Subject: EIS Advice - Mixed Use Development at 15-21 Cottonwood Crescent, Macquarie Park (SSD-94006708) (City of Ryde)

CPHR EIS Advice on Mixed Use Development at 15-21 Cottonwood Crescent, Macquarie Park (SSD-94006708) (City of Ryde)

● TREE RETENTION + REMOVAL PUBLIC DOMAIN & GROUND FLOOR

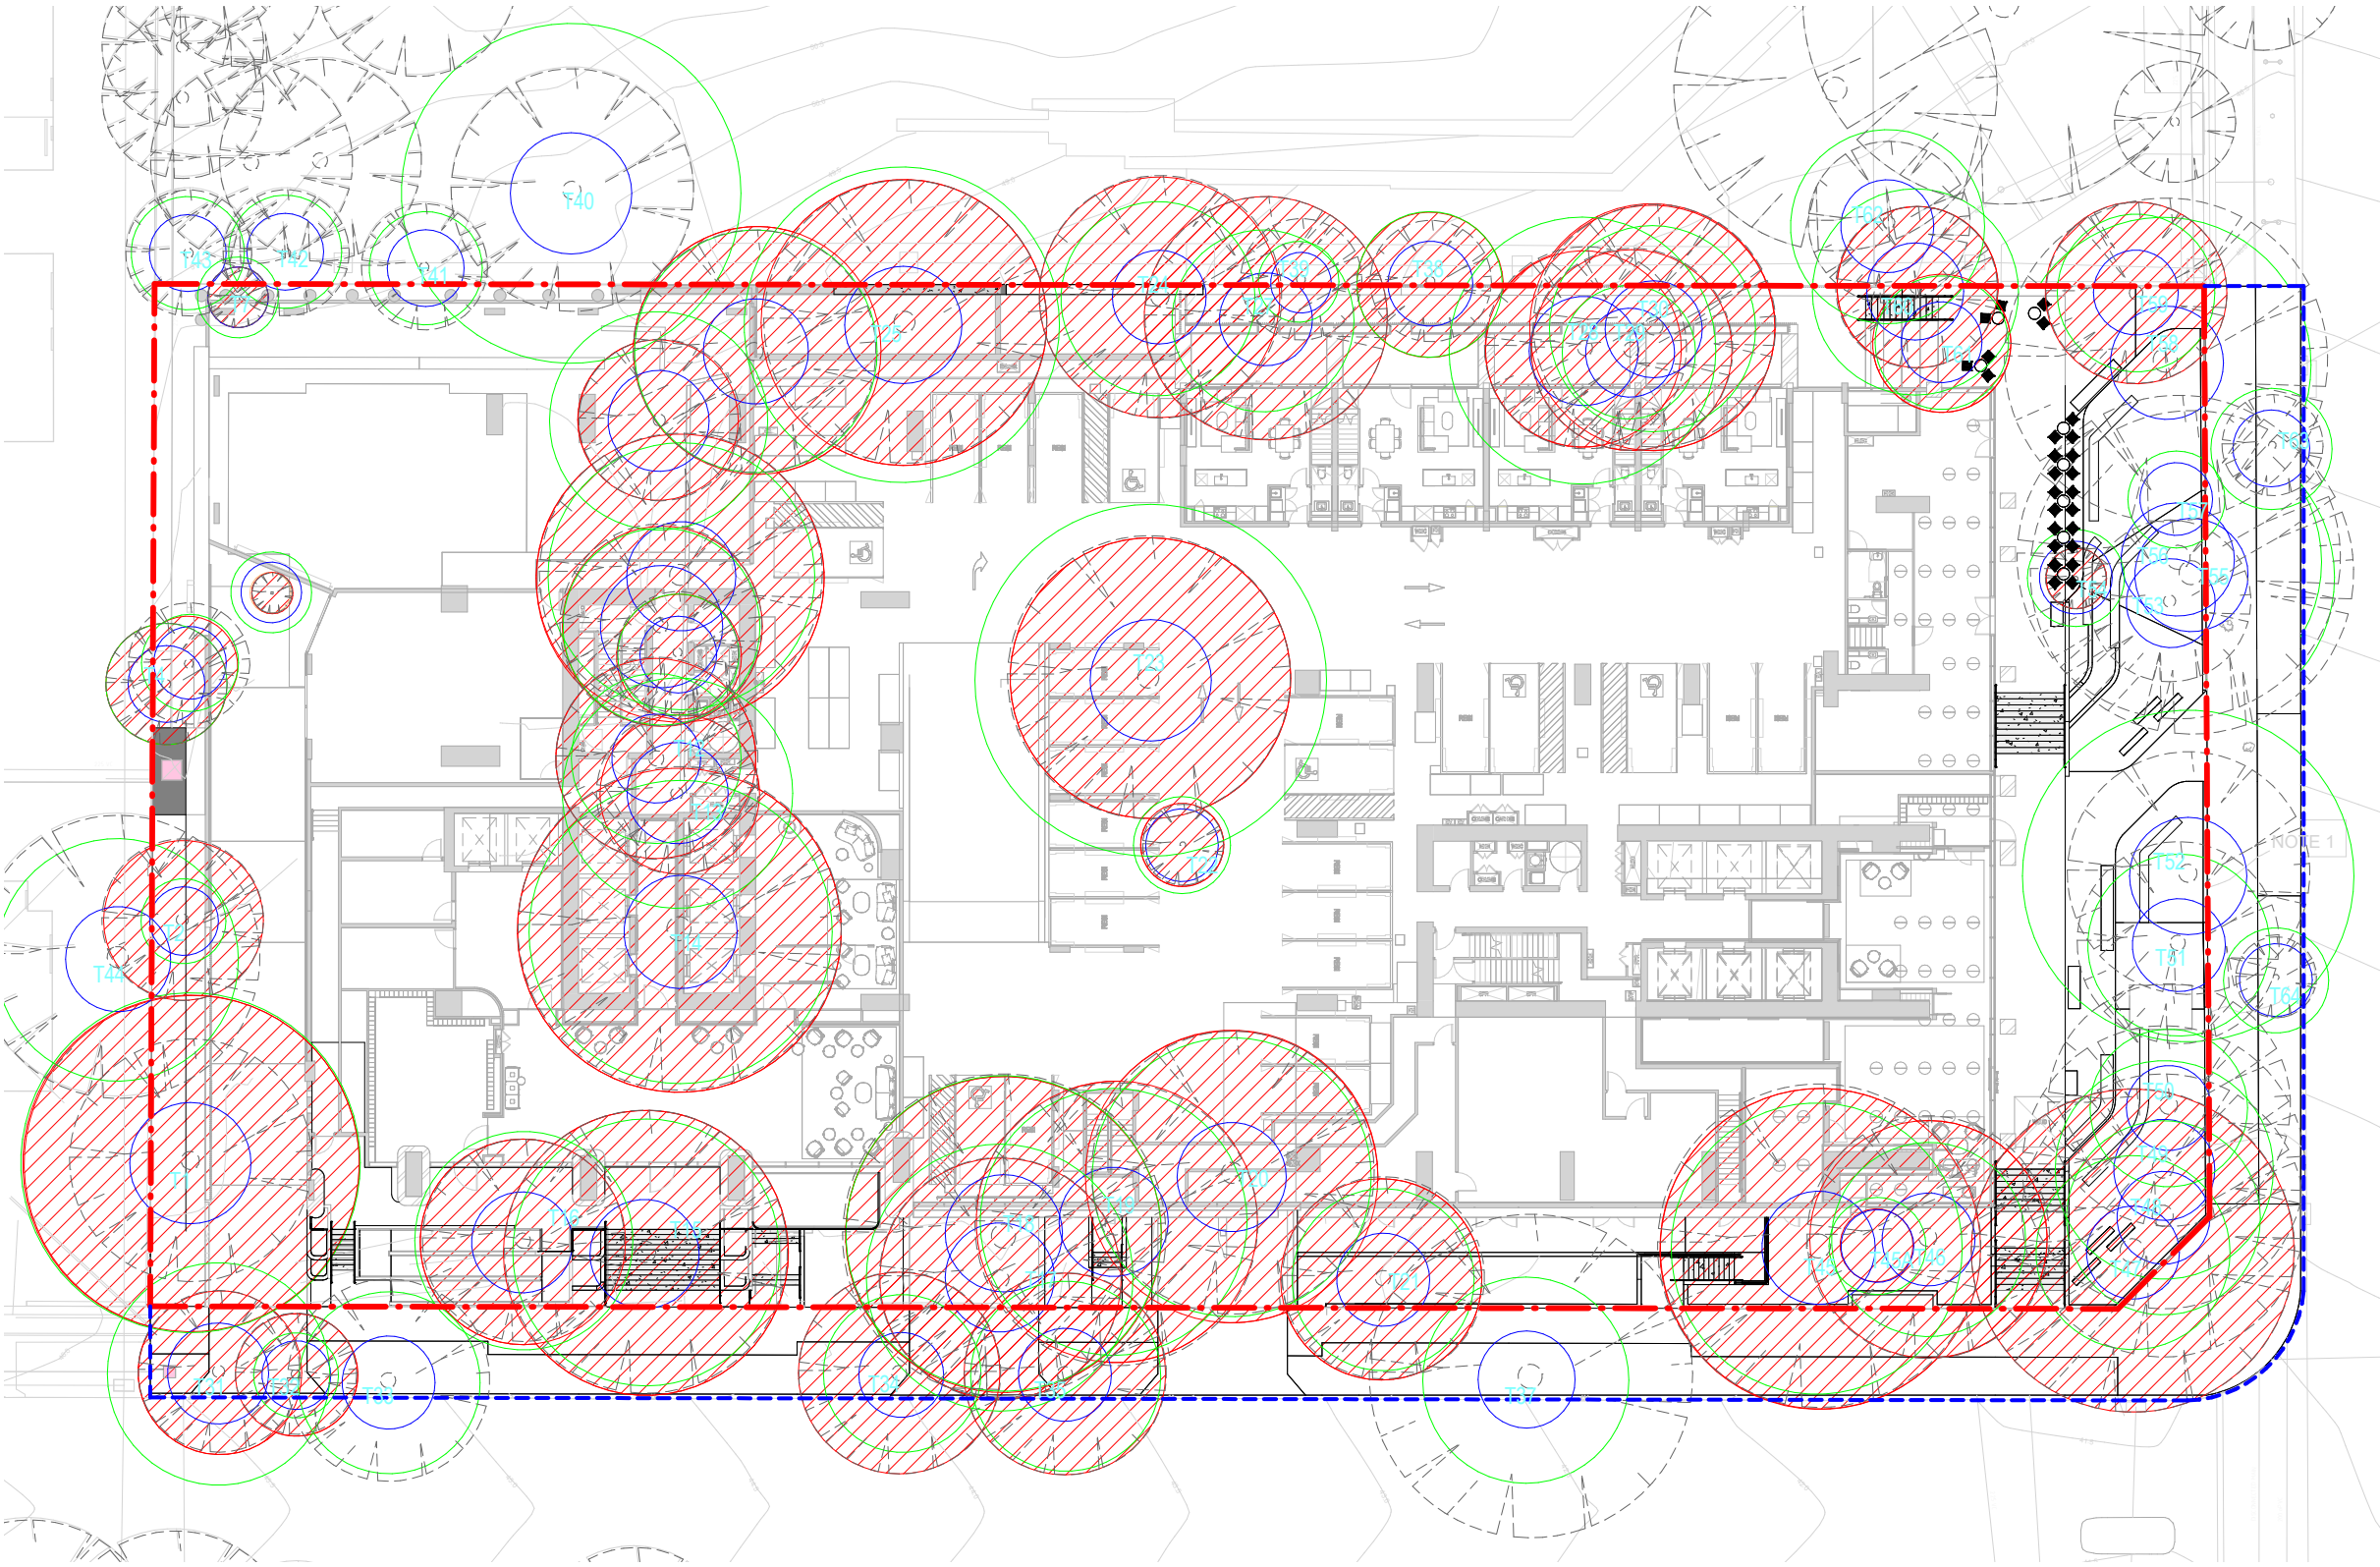
The proposal involves significant tree loss with 49 removed and seven retained. Greater effort should be made to retain trees due to their environmental and amenity benefits. CPHR notes uncertainty regarding compliance with the City of Ryde Development Control Plan (DCP) (s7.4a v) setback requirements and recommends a 5m setback from Elouera Reserve to improve opportunities for tree retention.

1.	<i>Plans to reflect AIA recommendations</i>	<p>Within the site trees 48, 49, 52, 53, 55, 56, and 58 will be retained, as well as two park trees 42 and 43, however, all will be subject to major encroachment. The AIA includes a number of mitigation measures to ensure retention.</p> <p>Recommended action: Include conditions of consent to require implementation of the mitigation measures outlined in the AIA, to ensure the ongoing viability of retained trees. Additionally, consideration should be given for the inclusion of the broader recommendations set out in Section 9 of the AIA.</p>
	<i>Extent and timing</i>	Prior to determination

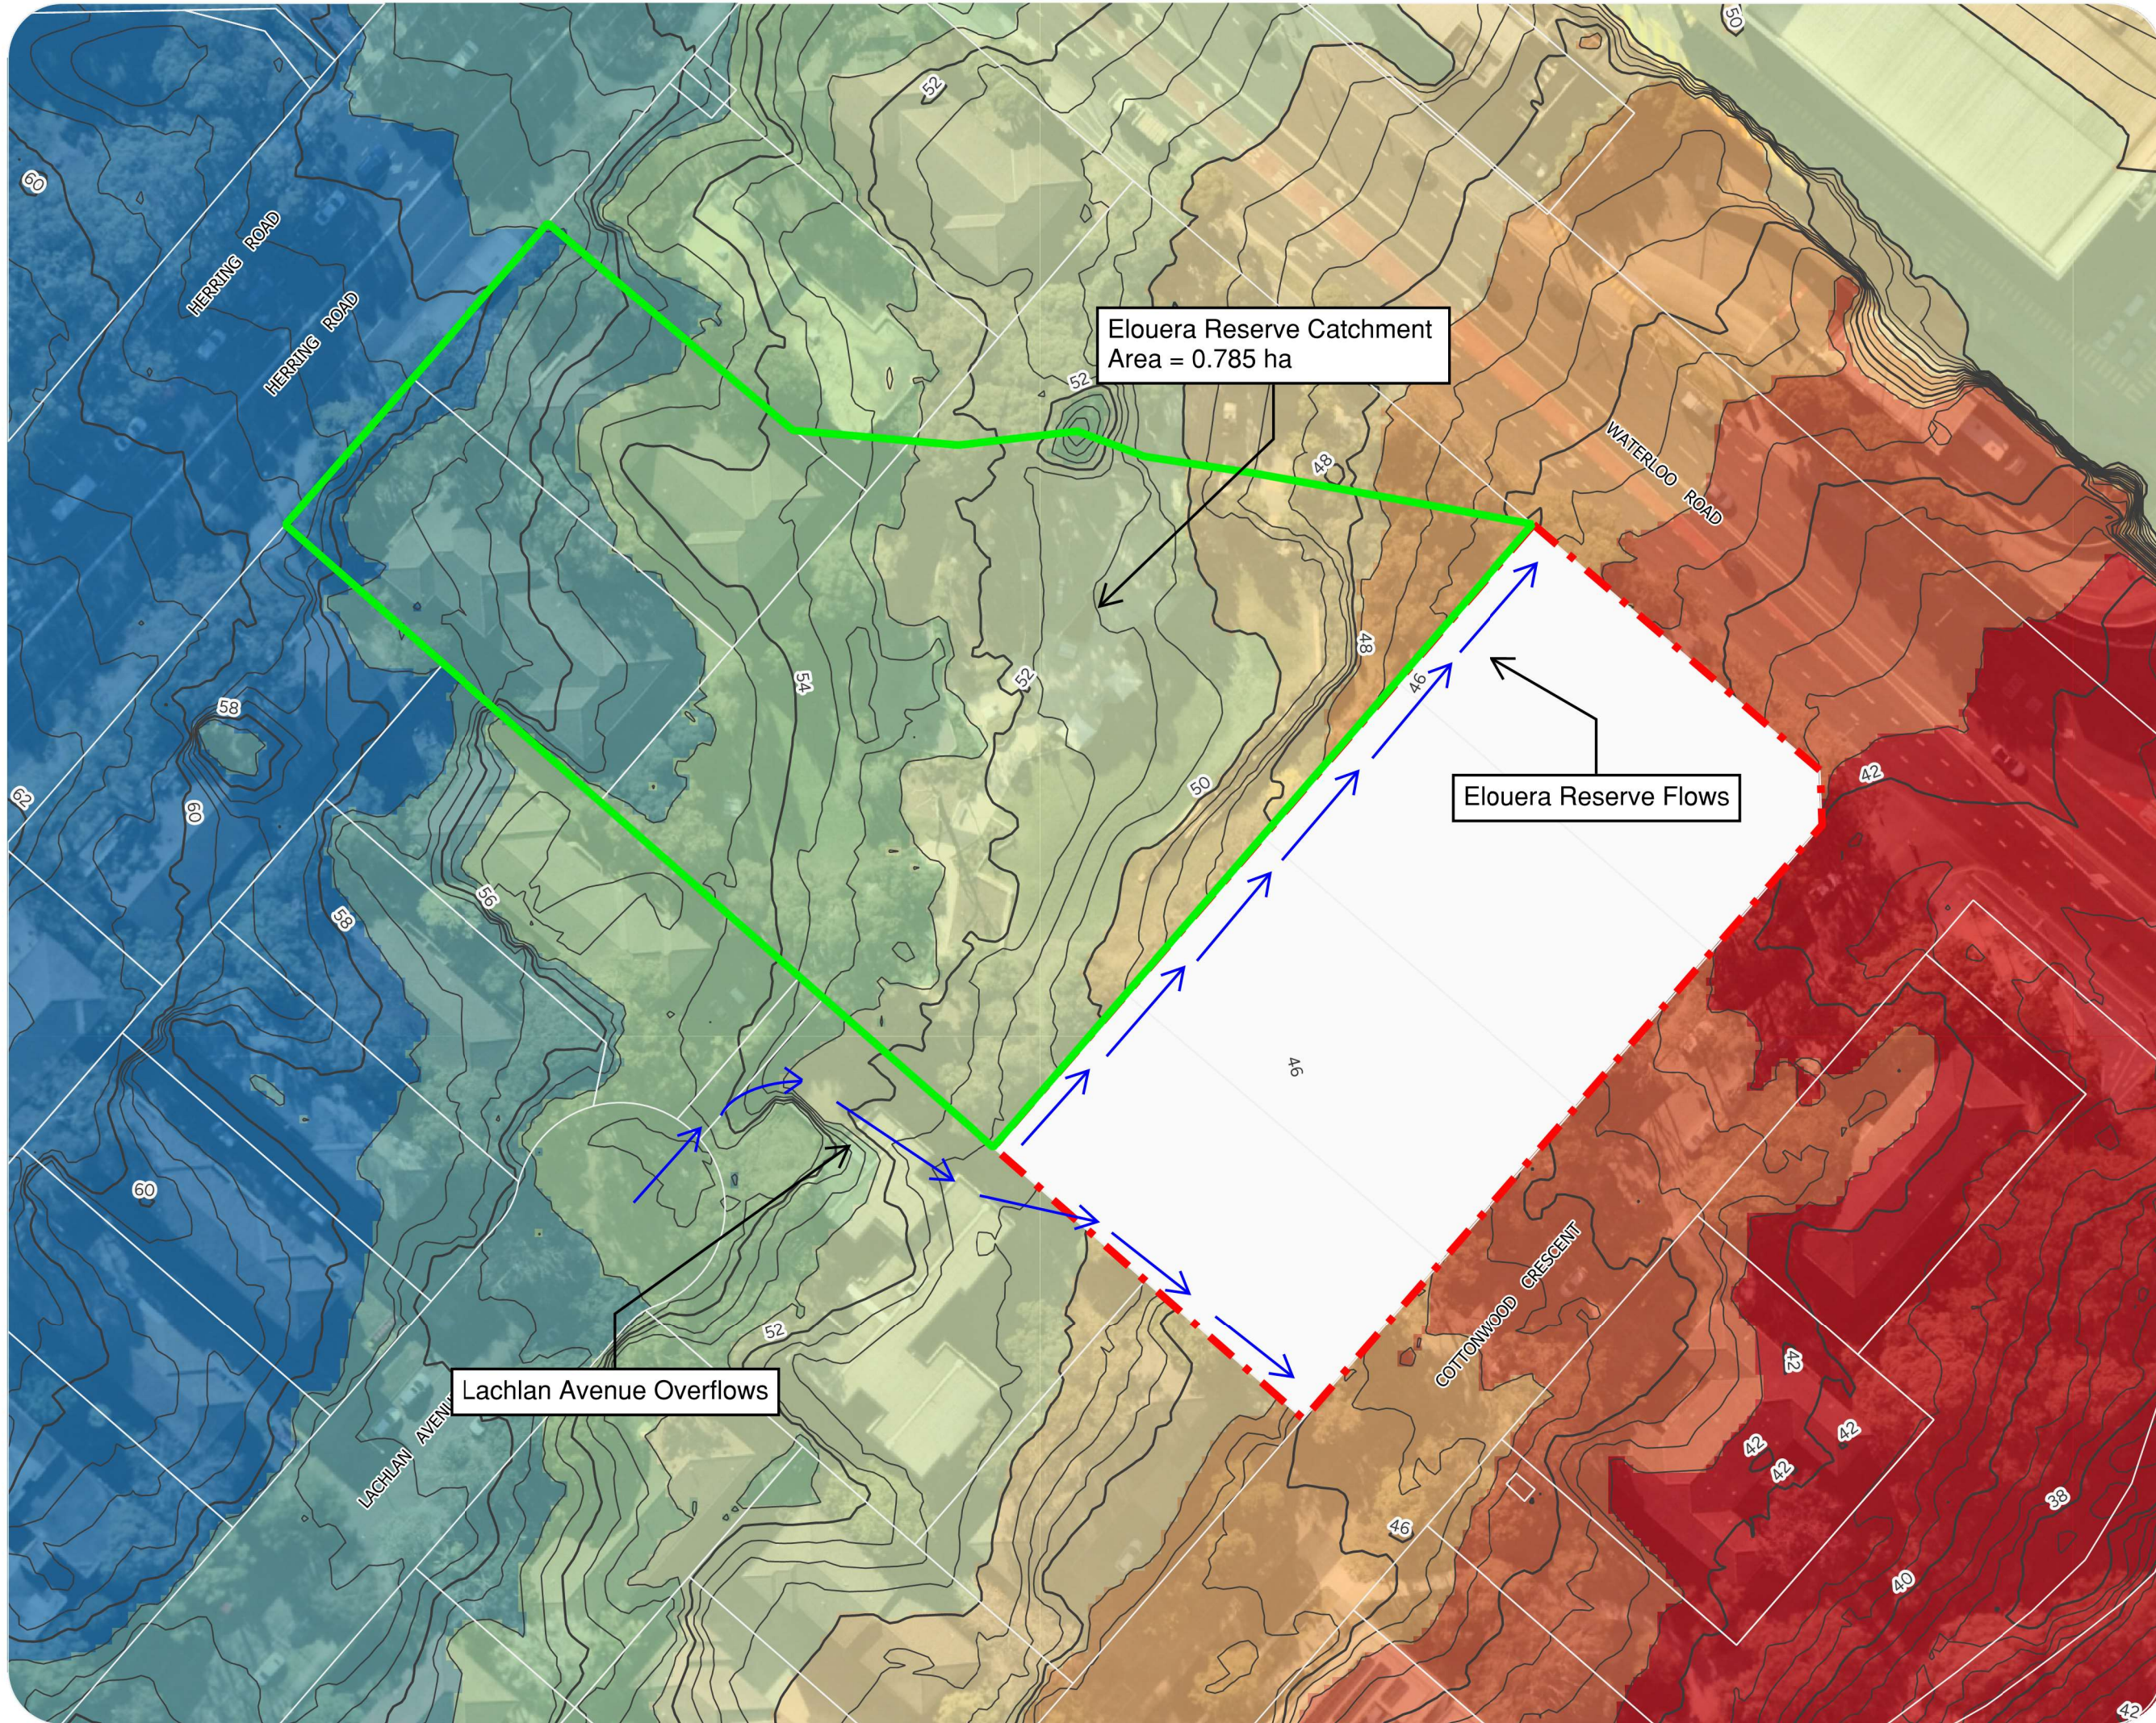
The proposal does not clearly state the flood design levels to be achieved and lacks details for the western swale and northern levee. Therefore it is unclear whether the site will be adequately protected from flooding. Emergency response arrangements are also vague, particularly given the increased number of residents, meaning both flood protection measures and flood response need to be clearly defined in the *Flood Impact and Risk Assessment* (FIRA) and design plans before determination.

2.	<i>Design levels</i>	<p>The design levels intended to protect the development from flooding are, in some locations, described as the higher of multiple criteria, such as 1% AEP Level, freeboard or PMF Level. However, the specific design levels required to meet these criteria are not clearly defined. This lack of clarity forms a risk that the required design levels may be misinterpreted by other parties.</p> <p>In addition, no design details have been provided for the swale along the western boundary of the site, nor for the levee or levee wall along the northern boundary. These details should be provided and the associated flood levels</p>
----	----------------------	--

<p>clearly identified to ensure that the development will be adequately protected from flooding and overland flow.</p> <p>Recommended action:</p> <ul style="list-style-type: none"> • Determine flow levels for the western overland flow path and northern levee wall to inform updates to the site design. • Clearly define the flood immunity design levels in the FIRA and ensure design plans are consistent with these levels.
	<i>Extent and timing</i>	Prior to determination
